# Rezoning Transportation Analysis

Petition Number: 2021-114

Date	Description
09-15-21	First Review (BKB)
10-18-21	Second Review (AO)
11-22-21	Third Review (PDM)

SHEET NO: RZ-1

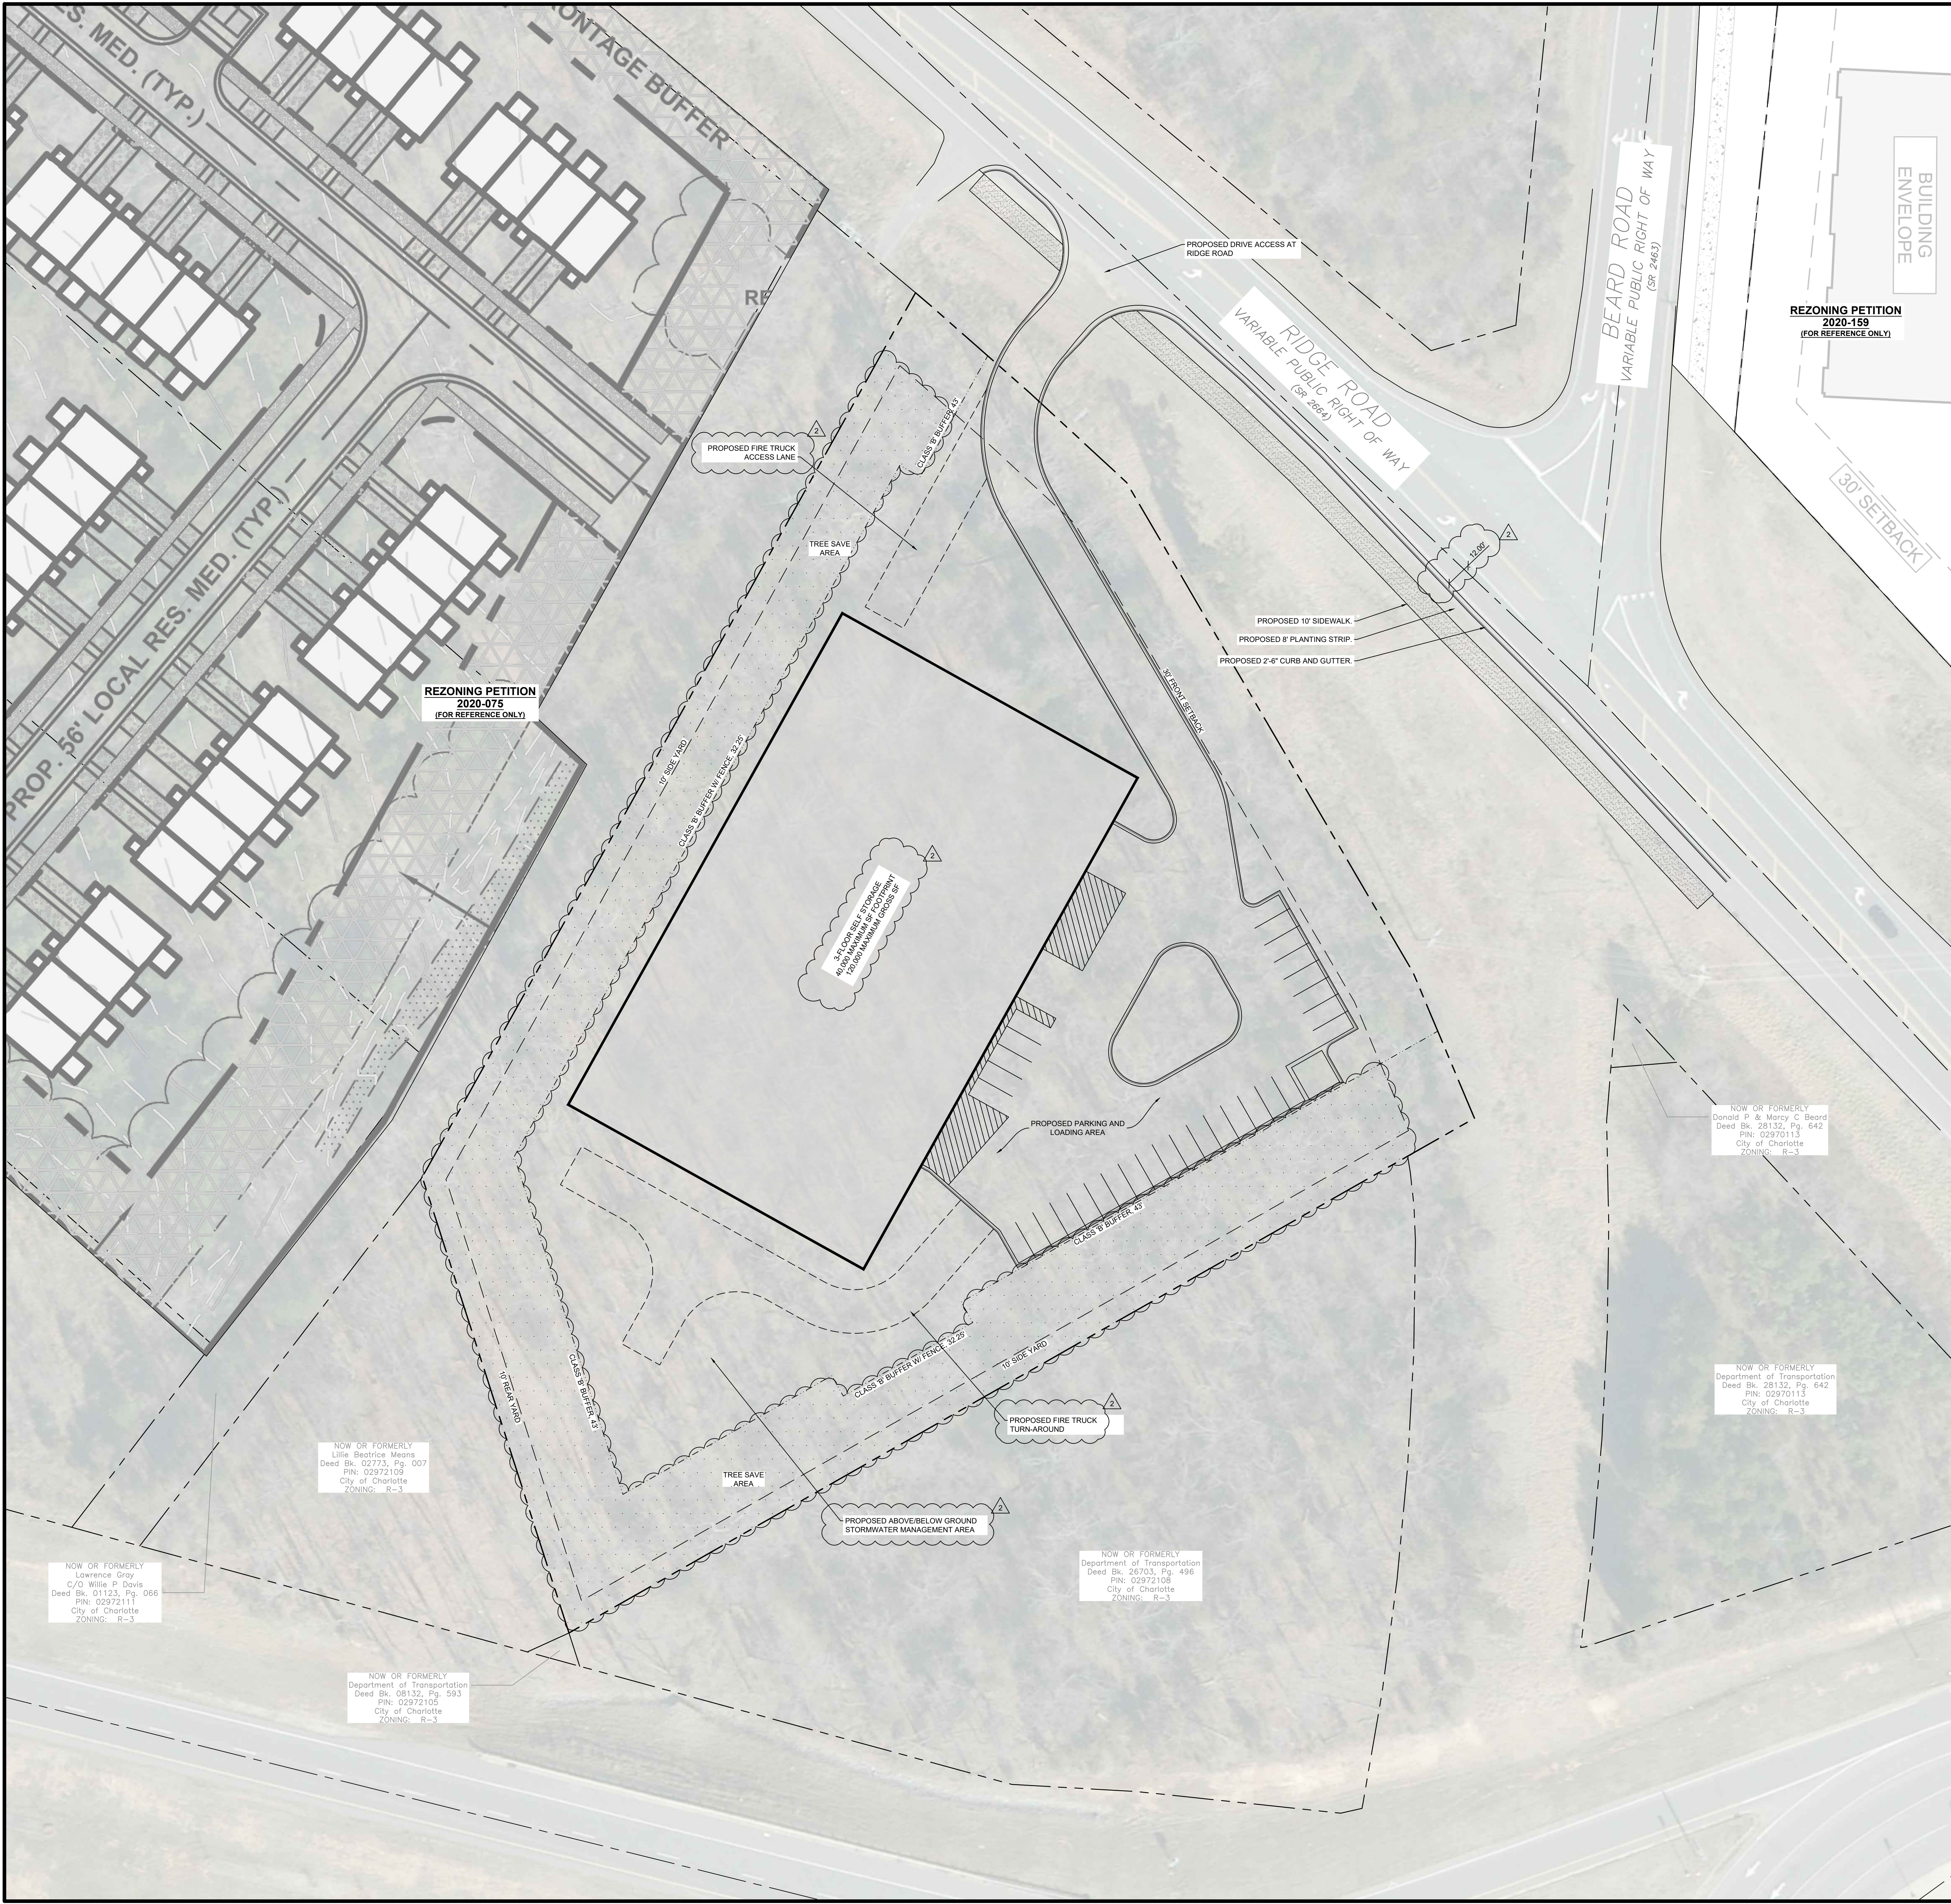
1. **Curbline:** The proposed zoning district has a setback measured from back of the existing or proposed future curbline.
  - a. **Ridge Road:** Provide curb and gutter along existing edge of travel lane along the entire property frontage. Use existing edge line for placement of gutter.

Label and dimension the curb and gutter from the centerline for Ridge Road on the site plan.

**Clarifying Comment from 9-15-21: Place curb and gutter off of edge of travel lane, not existing edge of pavement. Dimension the curb and gutter from the centerline of Ridge Road.**

**Clarifying Comment from 11-22-21: Place curb and gutter at edge of travel lane as depicted below.**

**3. Revise site plan and conditional note(s) to commit to construct an 8-foot planting strip, curb and gutter, and 10-foot sidewalk on Ridge Road per Chapter 19. The site plan shall label and dimension both items from the back of curb and gutter and road centerline.**

4. Site plan and revisions are needed to reflect the access point to the development on the western portion of the property per the below image. The existing Ridge Road and Beard Road intersection would require improvements that aren't commensurate with the development, so this relocated driveway will require less improvements of the developer within Ridge Road.
